Your Ref: OWPC25178
Our Ref: LY/13/19/HH 15-10-2019
Please ask for:
Zac Denton

New entrance/driveway, restoration of external building at the front of the property.
Restoration of walled garden, front and rear. Adjustment of levels around the property.
Restoration of all windows and small front porch area. Two storey extension including
demolition of existing extension. This application may affect the character and
appearance of the Lyminster Conservation area.

Lyminster Cottage Lyminster Road Lyminster

FIG A.

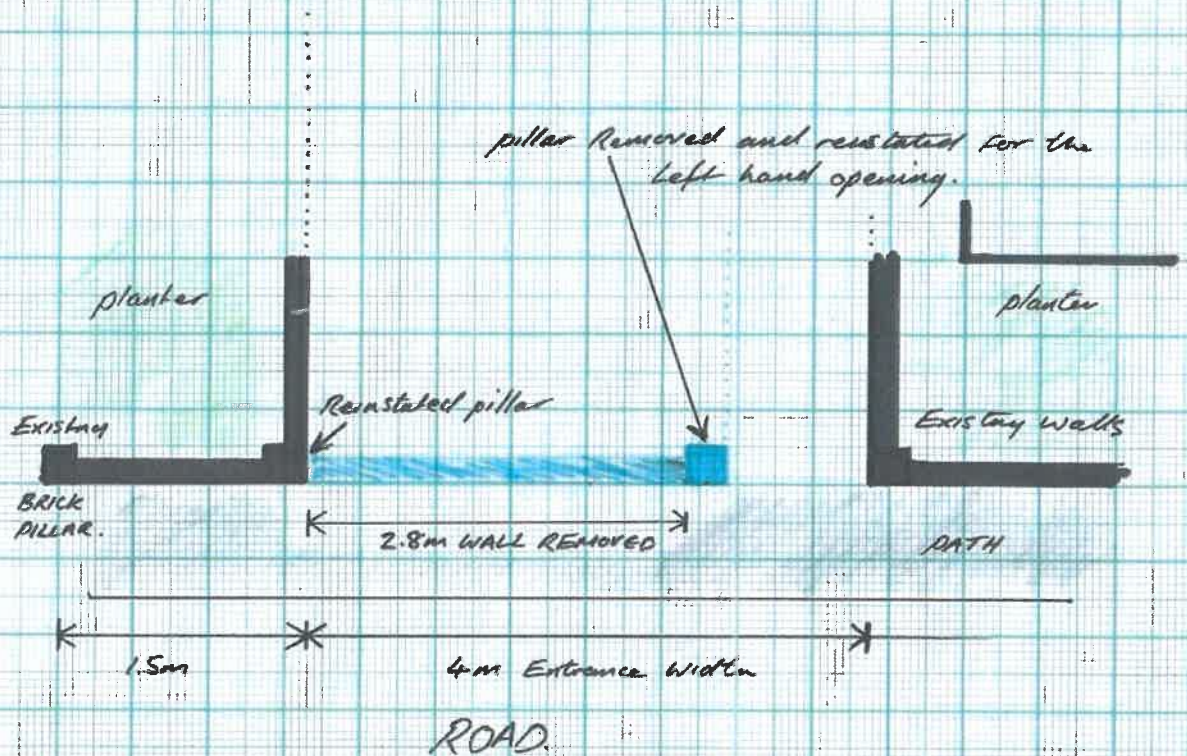
*The first would be from a safety aspect as this would be a very dangerous exit from a very
narrow driveway leading onto an already extremely busy congested A284.*

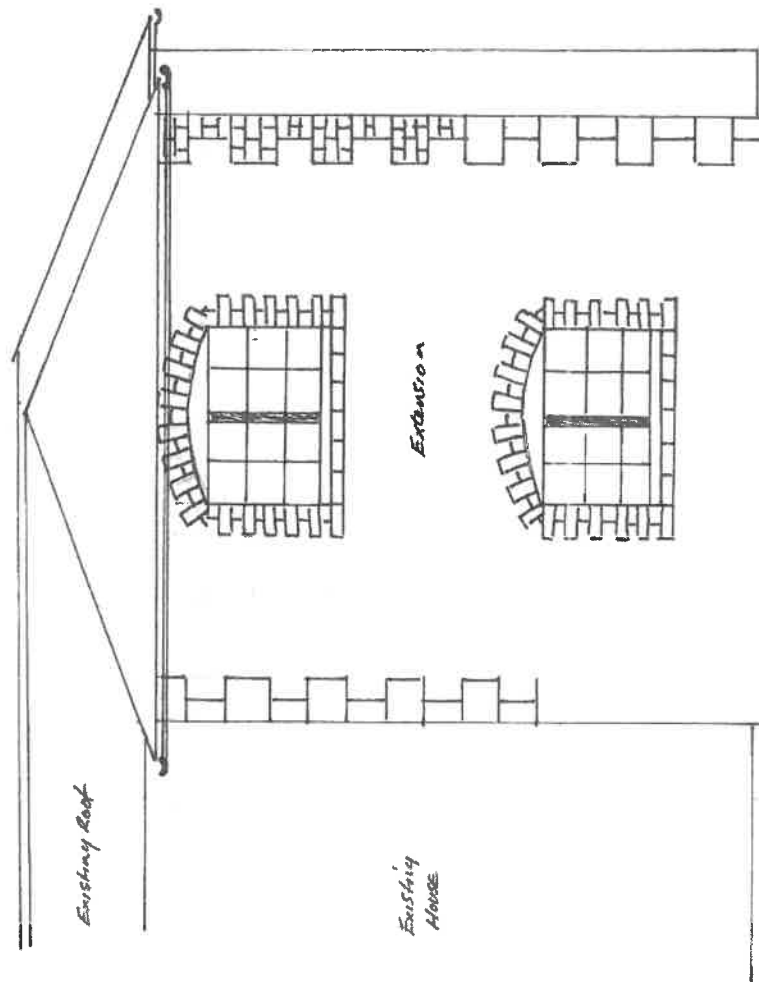
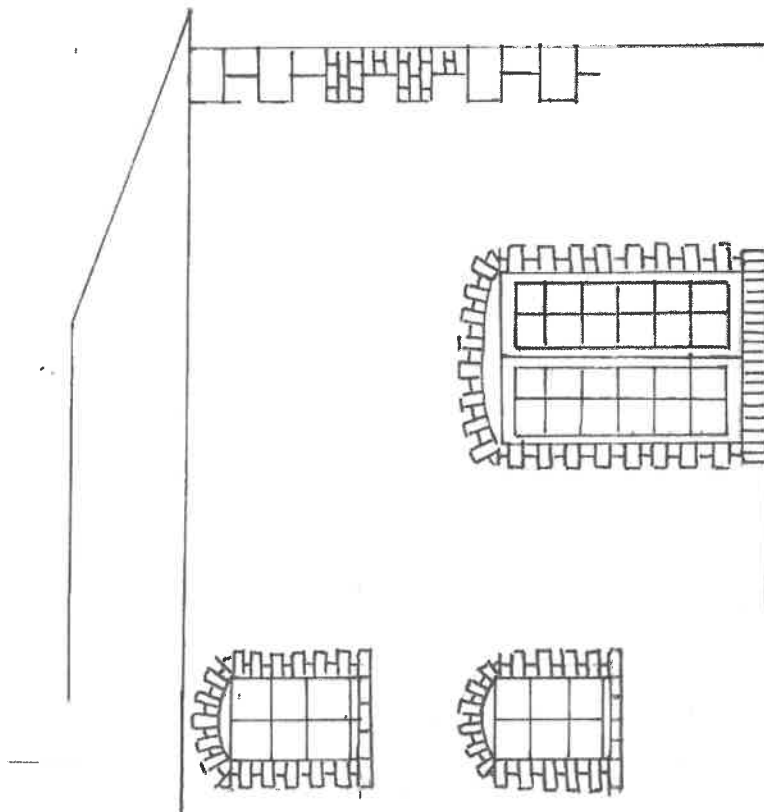
*Secondly this is a beautiful cottage in a CONSERVATION AREA and the addition of the
Second storey extension would be overbearing and ruin its aesthetic beauty and value.*
